Planning Inspectorate

Case ref: BC0410001

Application by SEGRO Properties Limited for an order granting development consent for East Midlands Gateway phase 2

Advice following issue of decision to accept the application for examination

number **FIGURE 8.2** rev
-

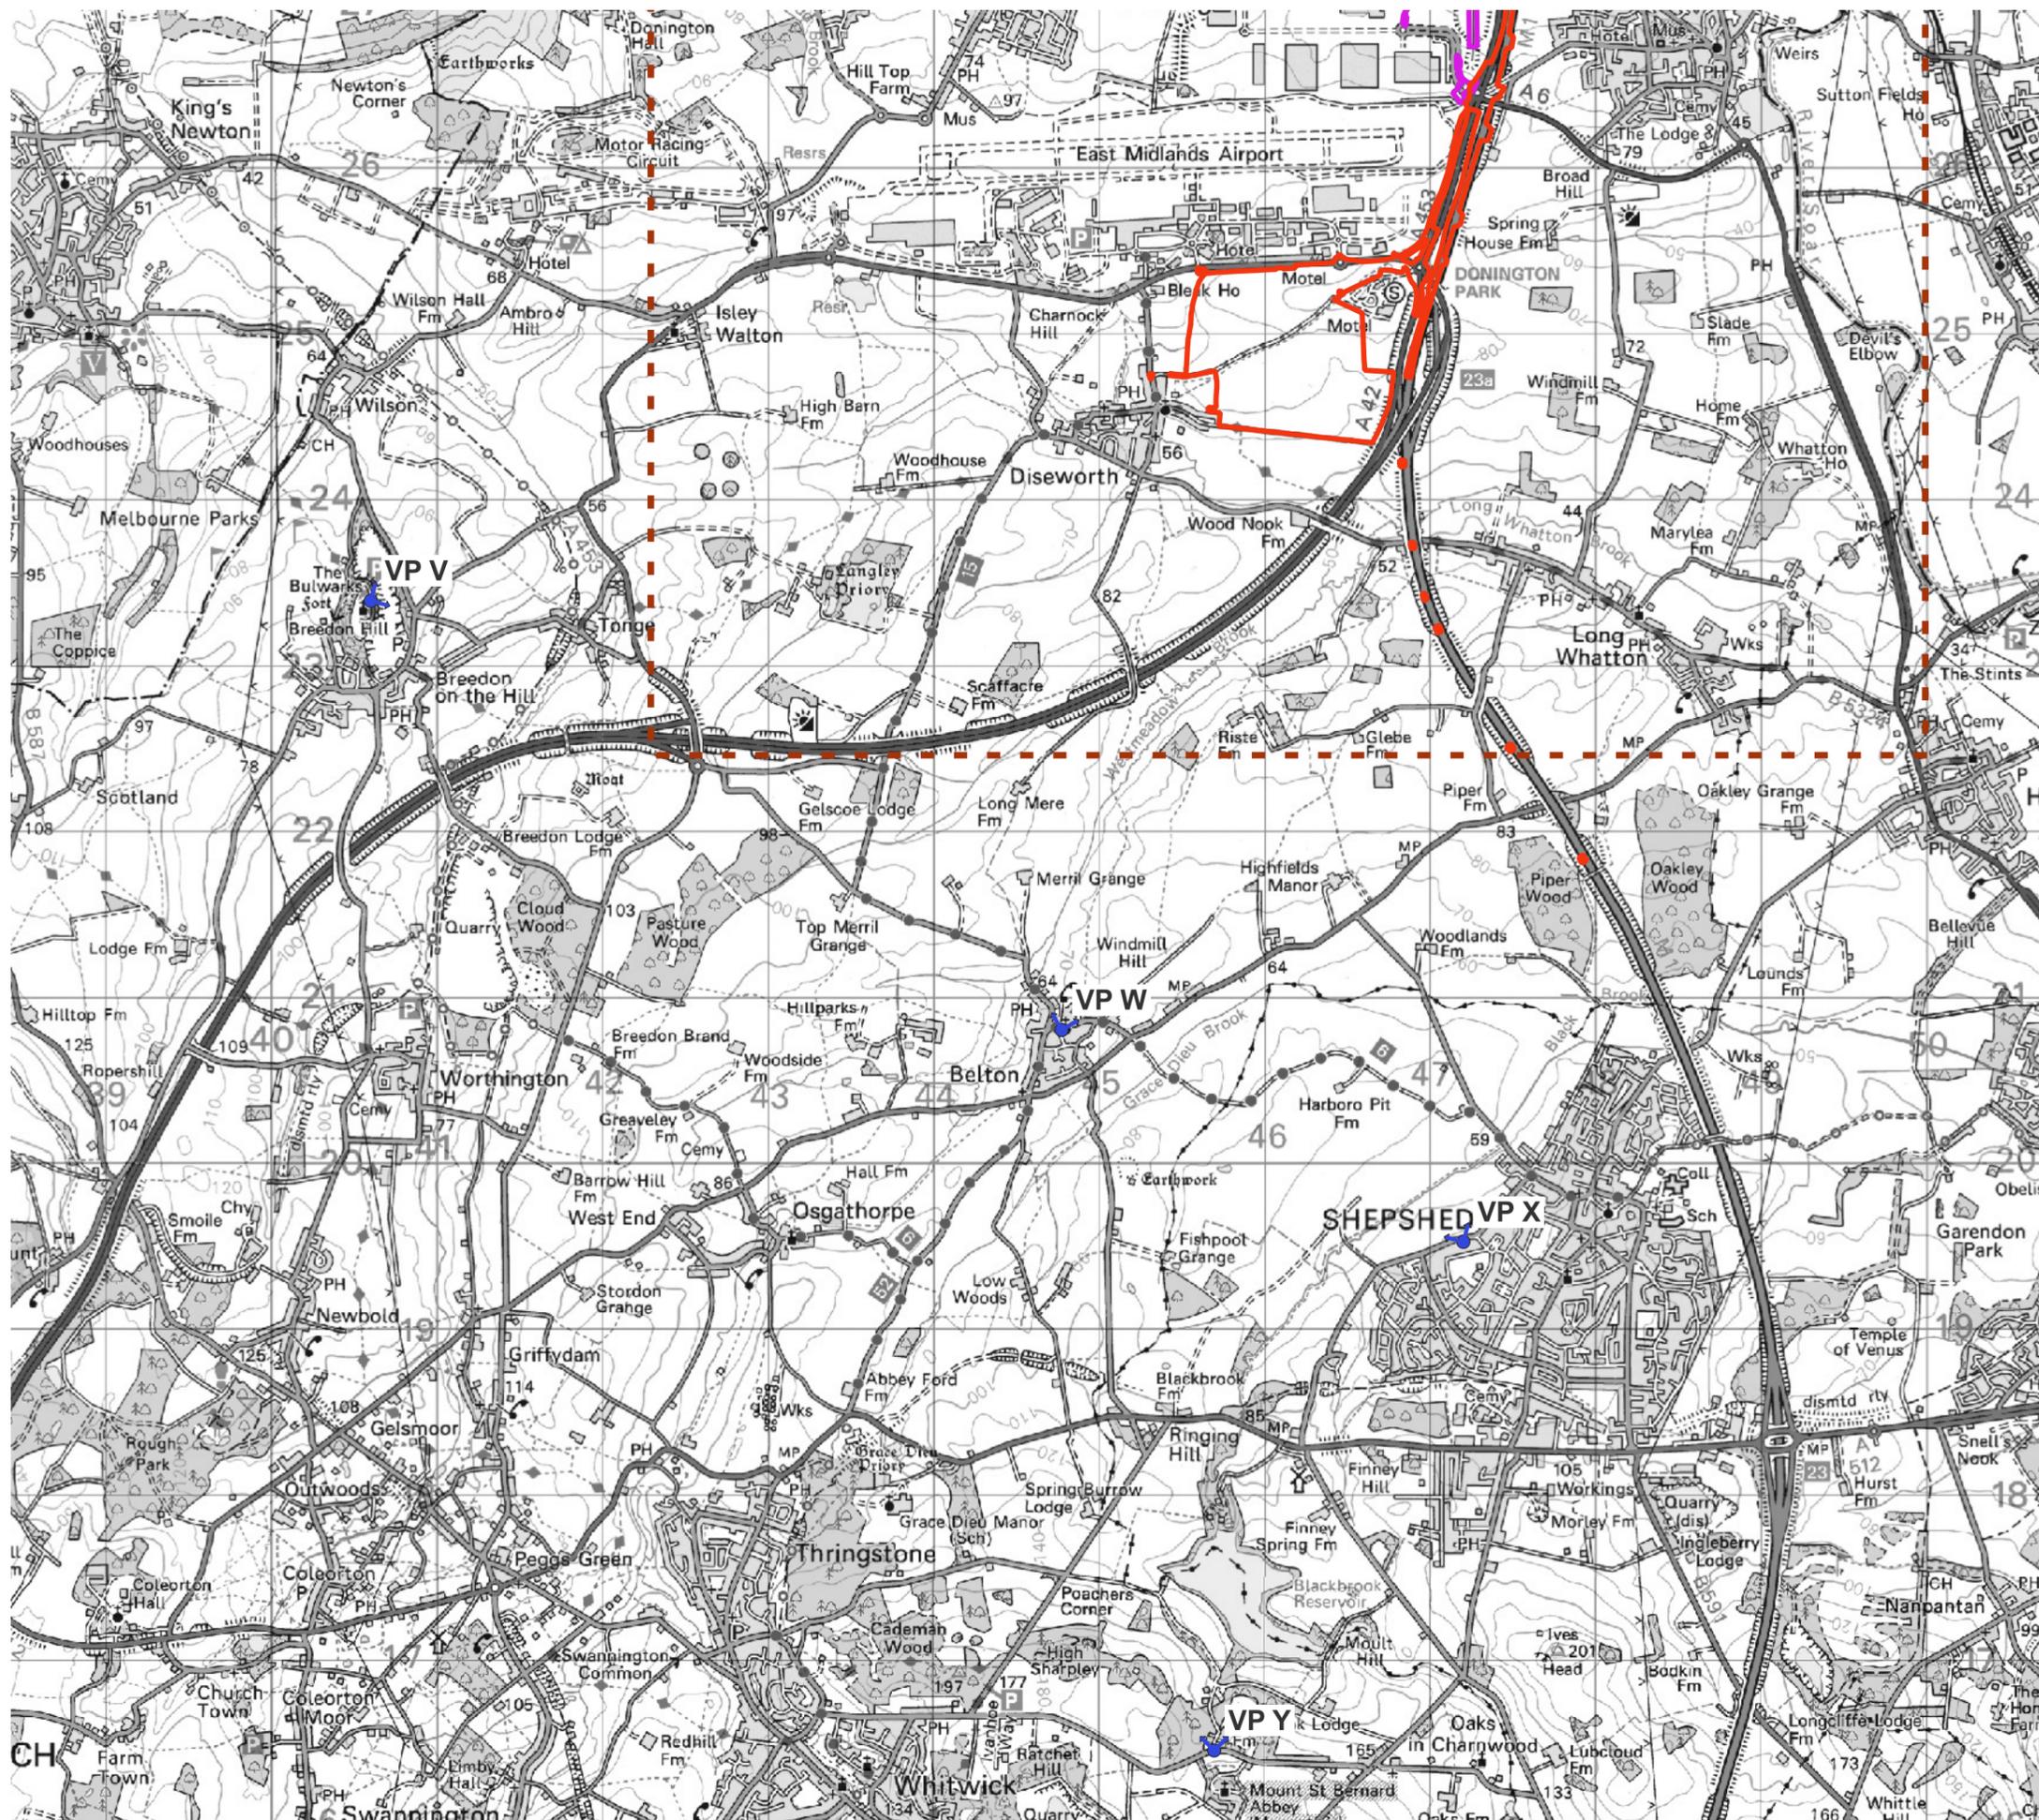
Figure 8.1 demonstrates those viewpoints where photomontages are provided. Photoviewpoints D, E, F and G do not appear to have photomontages but it is also not easy to follow whether these correspond to the viewpoints described in the text when referring to Figure 8.1. Photoviewpoint A also appears to be a different background image in the existing view to that provided for the photomontages at years 0 and 15 for the same viewpoint. Clearer referencing of viewpoints and photomontages should be provided and ensure that appropriate photomontages are provided for all receptors where significant effects are predicted to occur in years 0 and 15.
